Rezoning Transportation Analysis

Petition Number: 2021-127

Date	Description
09-23-2021	First Review (KP)

STEELE CREEK ROAD IMPROVEMENT INSET

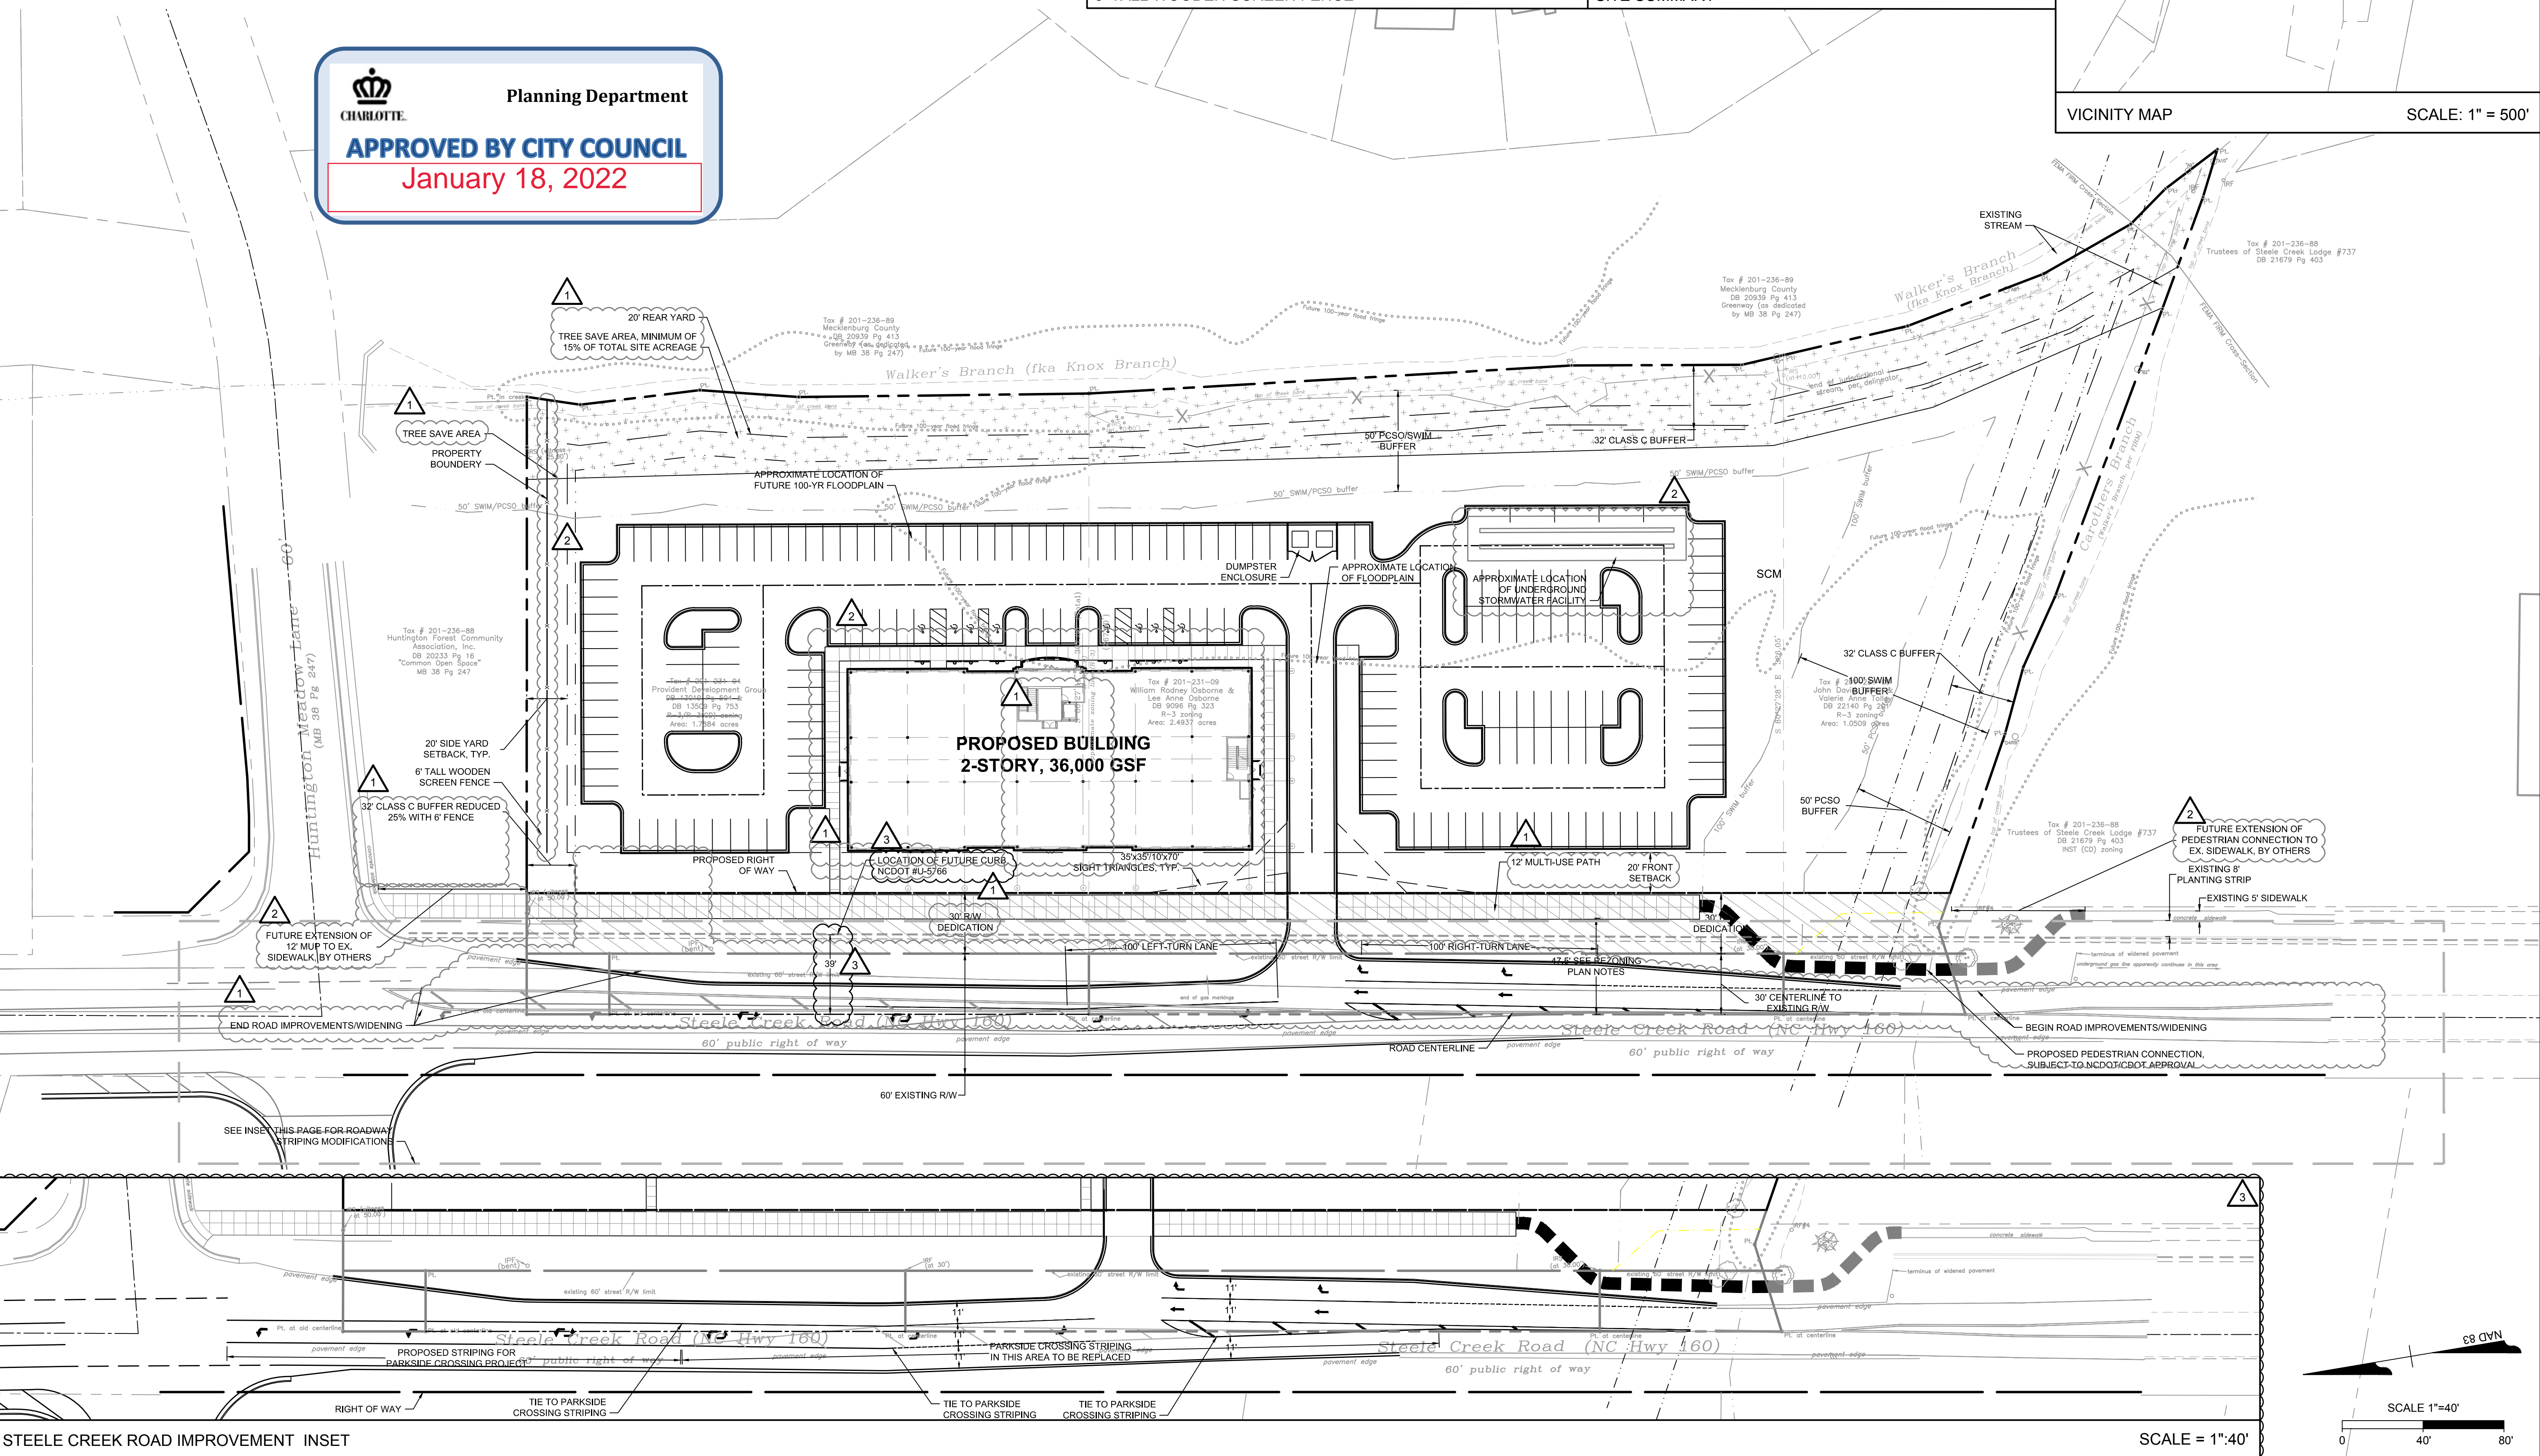
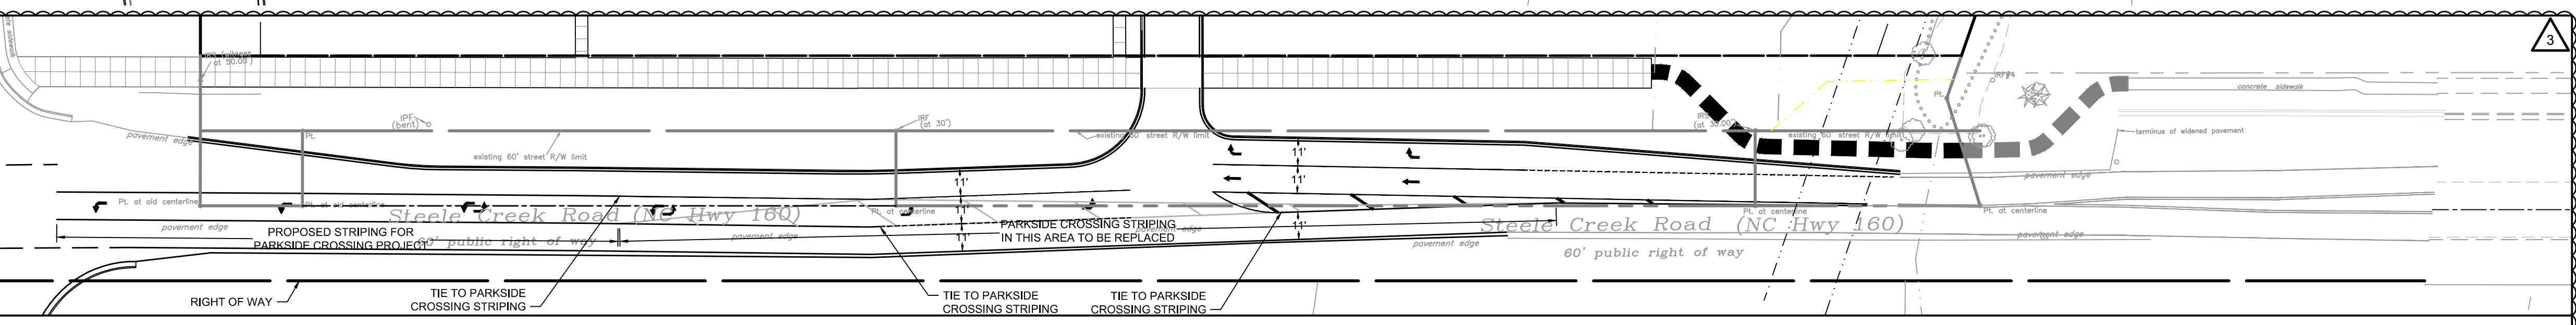
Label and dimension the future back-of-curb from the existing road centerline.

3. In accordance with the typical section associated with U-5766, please refer to outstanding issue 1.a, revise site plan and conditional note(s) to commit to dedicate 60-feet of right-of-way from the existing road centerline. The site plan shall label and dimension the right-of-way from the road centerline.
4. In accordance with the typical section associated with U-5766, please refer to outstanding issue 1.a, revise site plan and conditional note(s) to commit to construct an 8.5-foot planting strip, and a 12-foot shared-use path. Label and dimension the shared-use path from the existing centerline of Steele Creek Road.

5. Revise the site plan and conditional notes to commit to widen Steele Creek Road and provide a left-turn lane and a right-turn lane into the site. Each turn lane will have 100-feet of storage and an appropriate bay taper length. The widening and turn lanes will be designed and constructed in accordance with NCDOT standards and will be subject to NCDOT approval during permitting.

6. Revise the site plan by removing the northern driveway and providing one access point into the site.

7. Revise the site plan and conditional note(s) by removing the parking along the access drive and providing a 100-foot protected driveway stem.

9. Revise the site plan and conditional notes to connect the 12-foot shared-use path to the existing sidewalk at Huntington Meadows Lane.

10. Revise the site plan and conditional notes to provide a pedestrian connection from the southern rezoning boundary to the existing sidewalk stub on Steele Creek Road. This pedestrian connection will be subject to NCDOT and CDOT approval.
